18/12/2019

Our Ref: R/2015/15/E
2019/639595

**Section 4.55(2) modification to SSD 7037
75-85 Harrington Street, The Rocks**

PROPOSED PUBLIC PEDESTRIAN RAMP

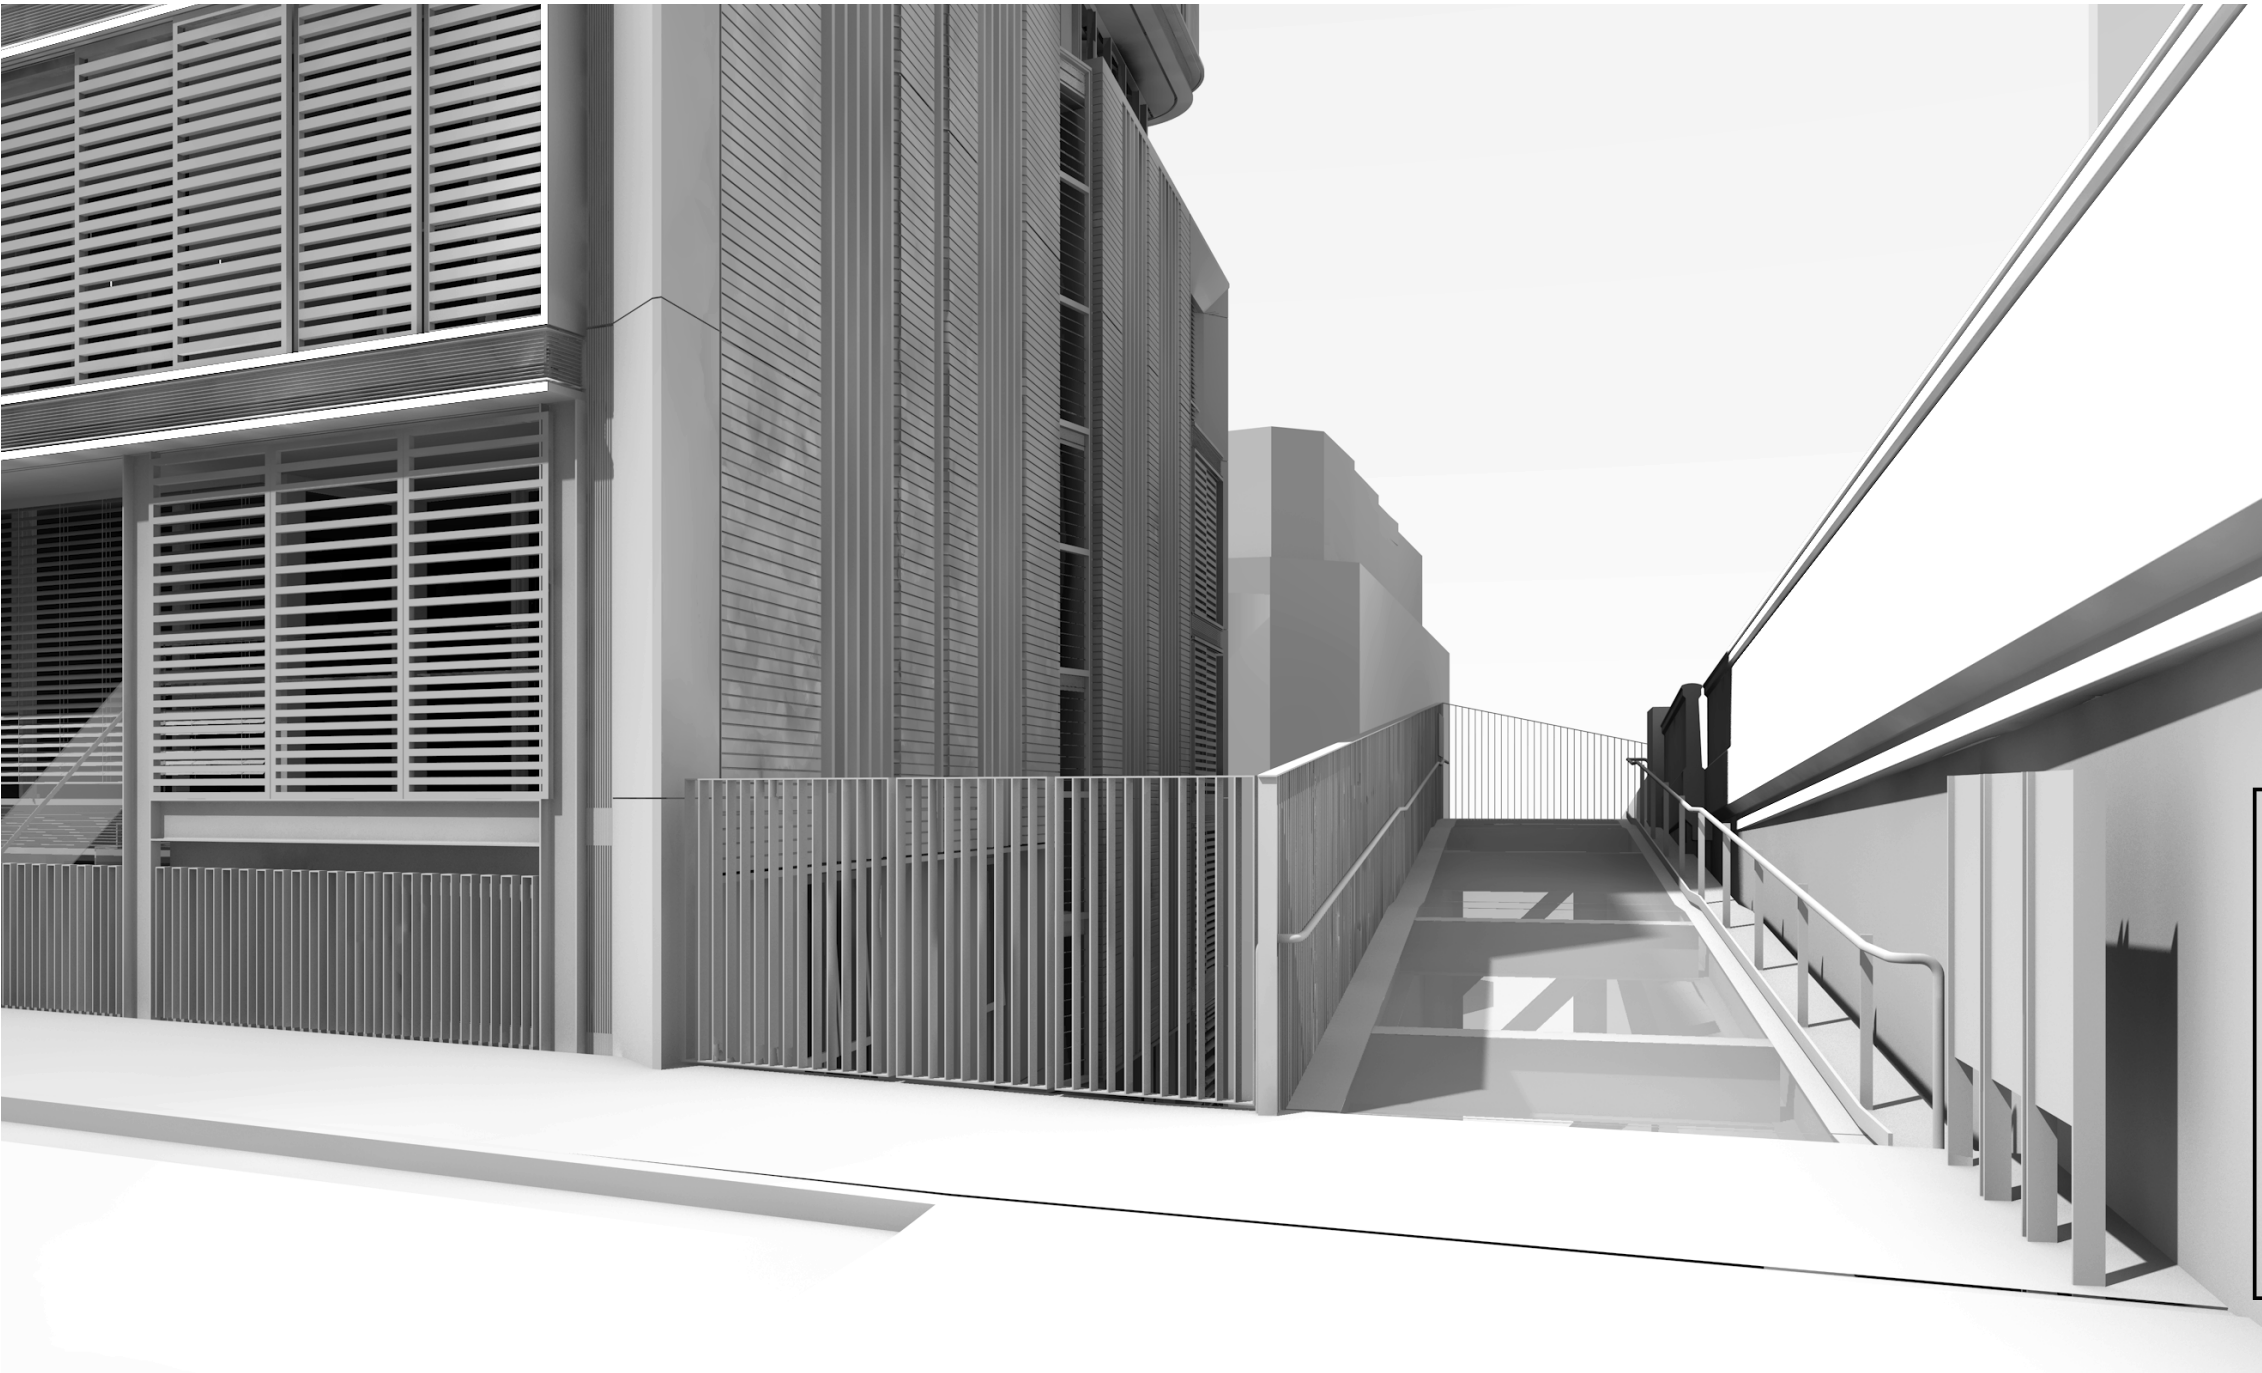
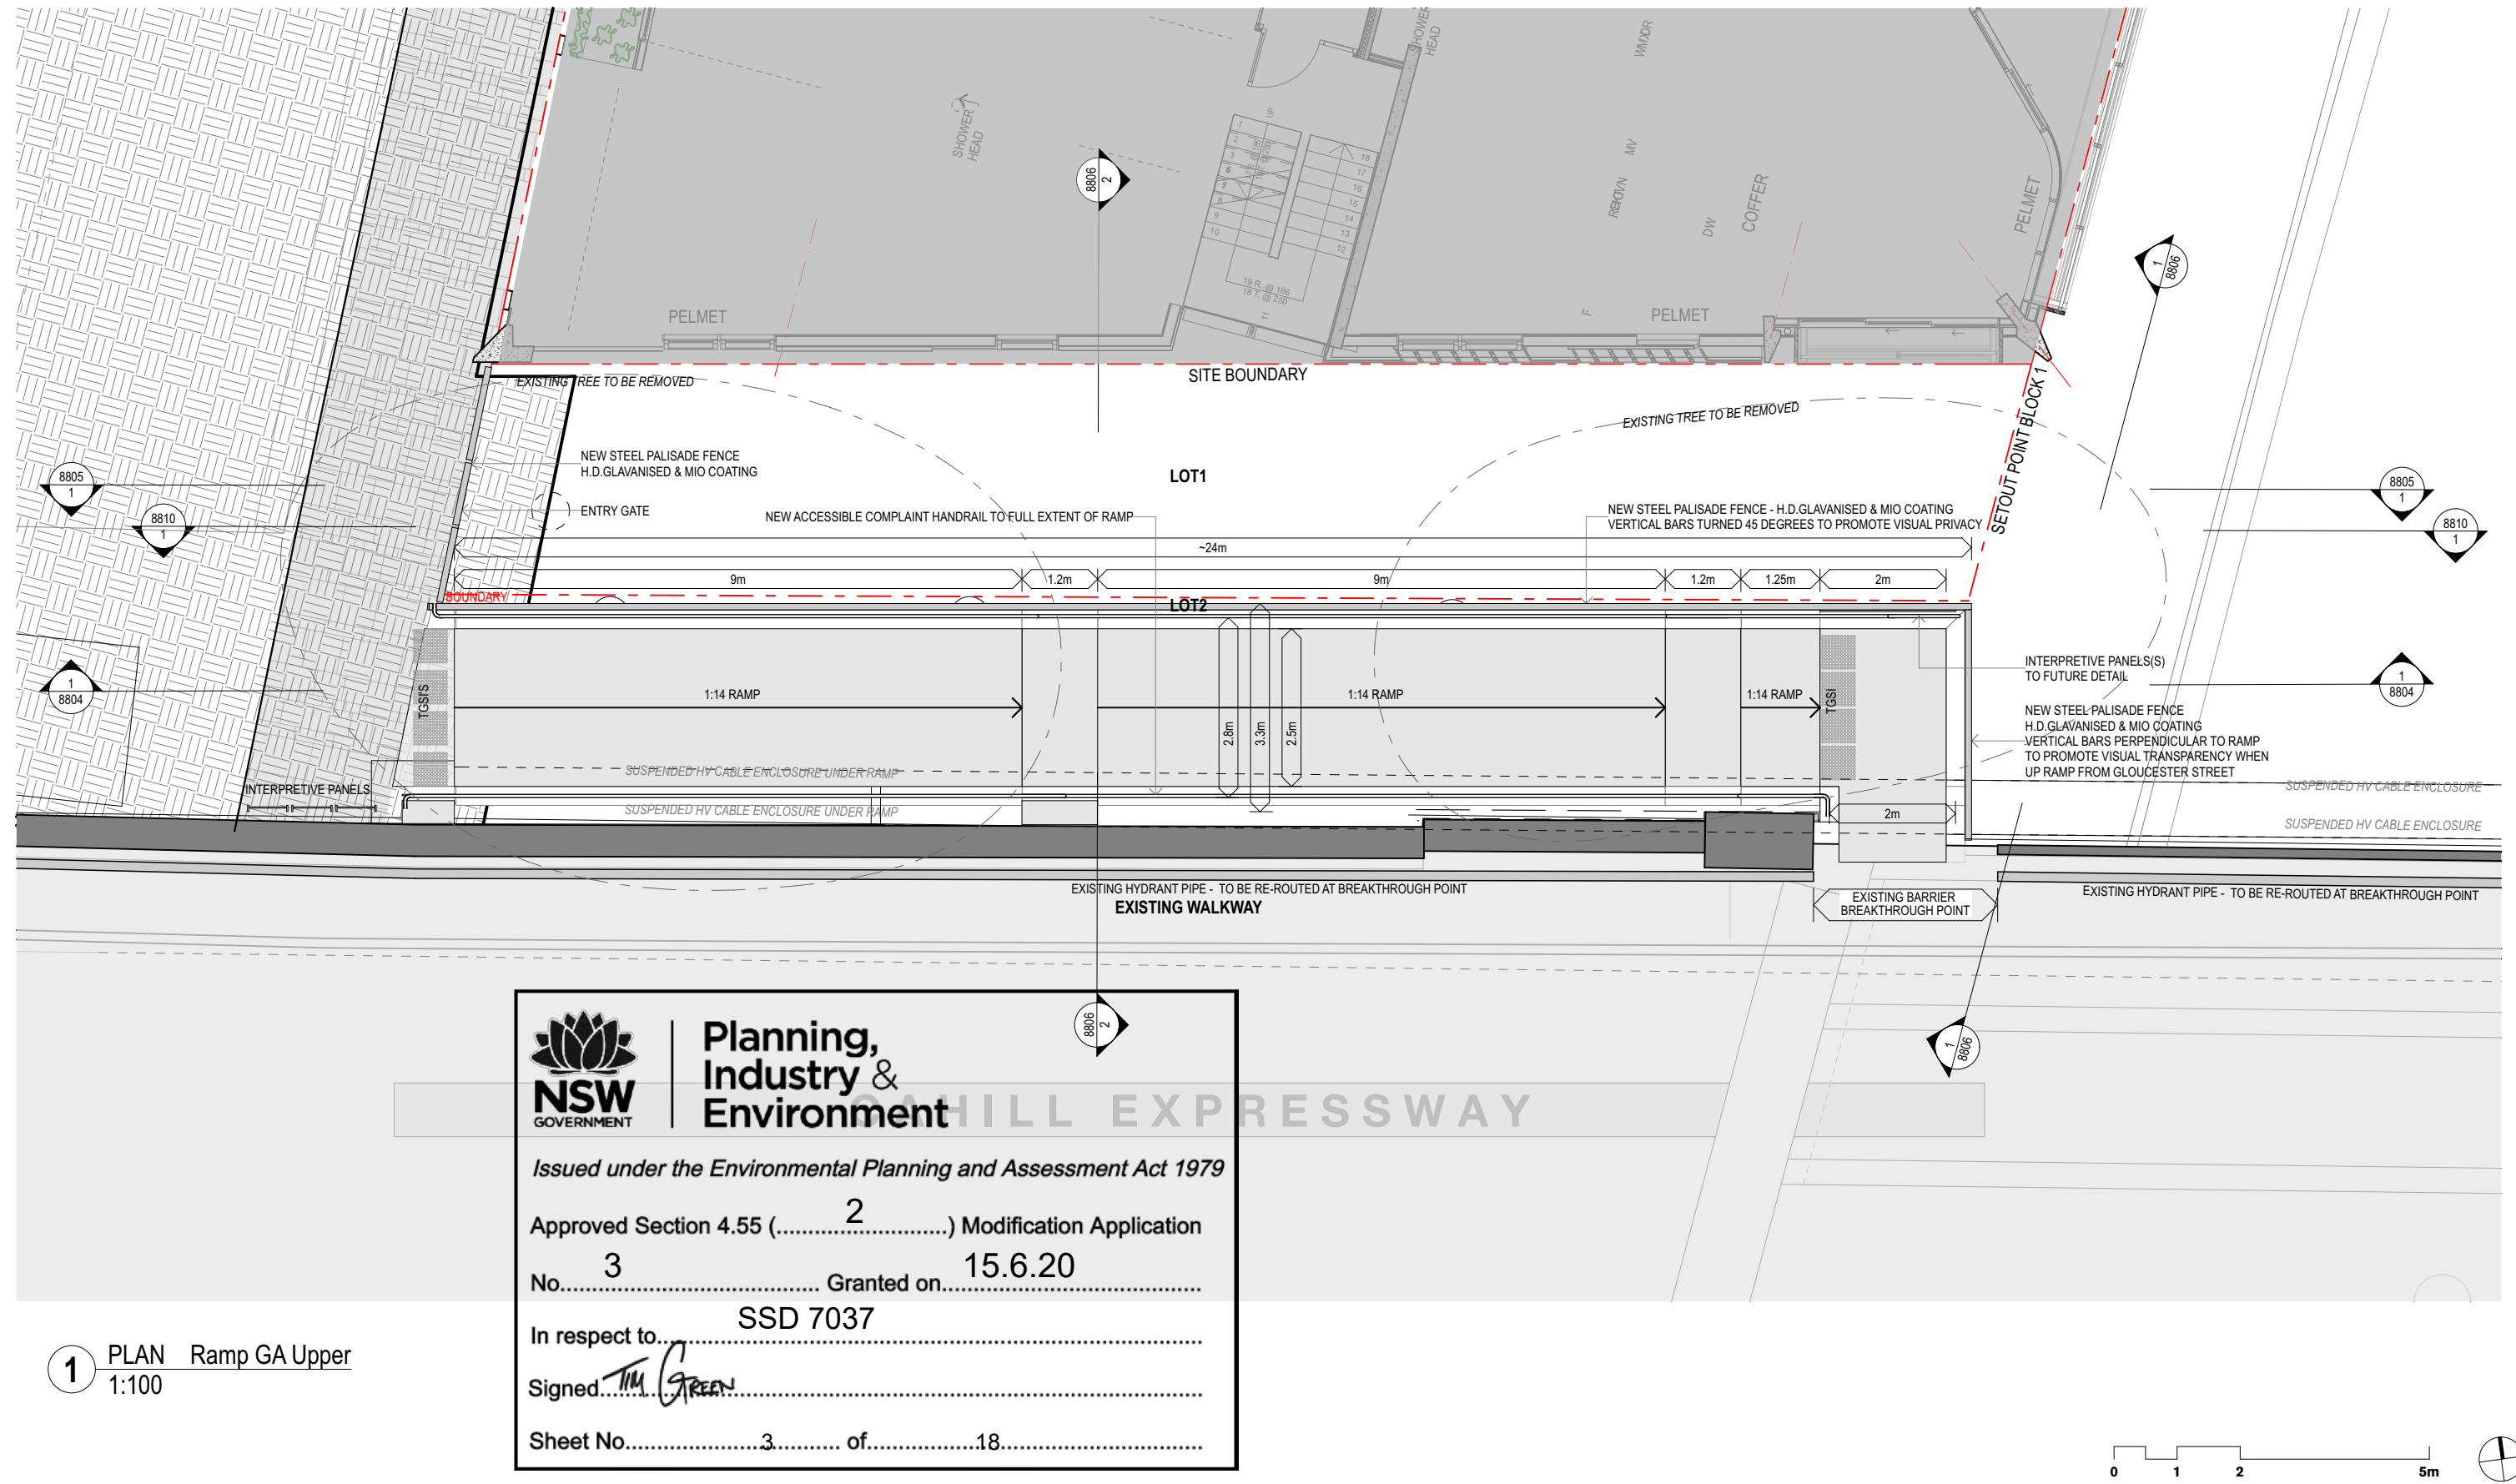
The long promised ramp is very welcome, and is not only a part of the City of Sydney's *Cycle Strategy and Action Plan 2018-2030*, as mentioned, but is also a key link in the NSW Government's *Sydney City Centre Access Strategy* (2013).

The *Sydney City Centre Access Strategy* has three east-west bike routes across the city centre, the northern one being alongside the Cahill Expressway. This project should provide the missing access to the State government's Cahill Expressway bike route – including for people riding who have children with them or on their bikes and those who have a disability and use their bikes as a mobility aid.

As such, it is not appropriate to have a discontinuous facility which requires or forces people to dismount. The Department of Planning Industry and Environment should ensure that this new infrastructure is fit for purpose and fulfils NSW Government strategies and plans, and is consistent with its original intent.
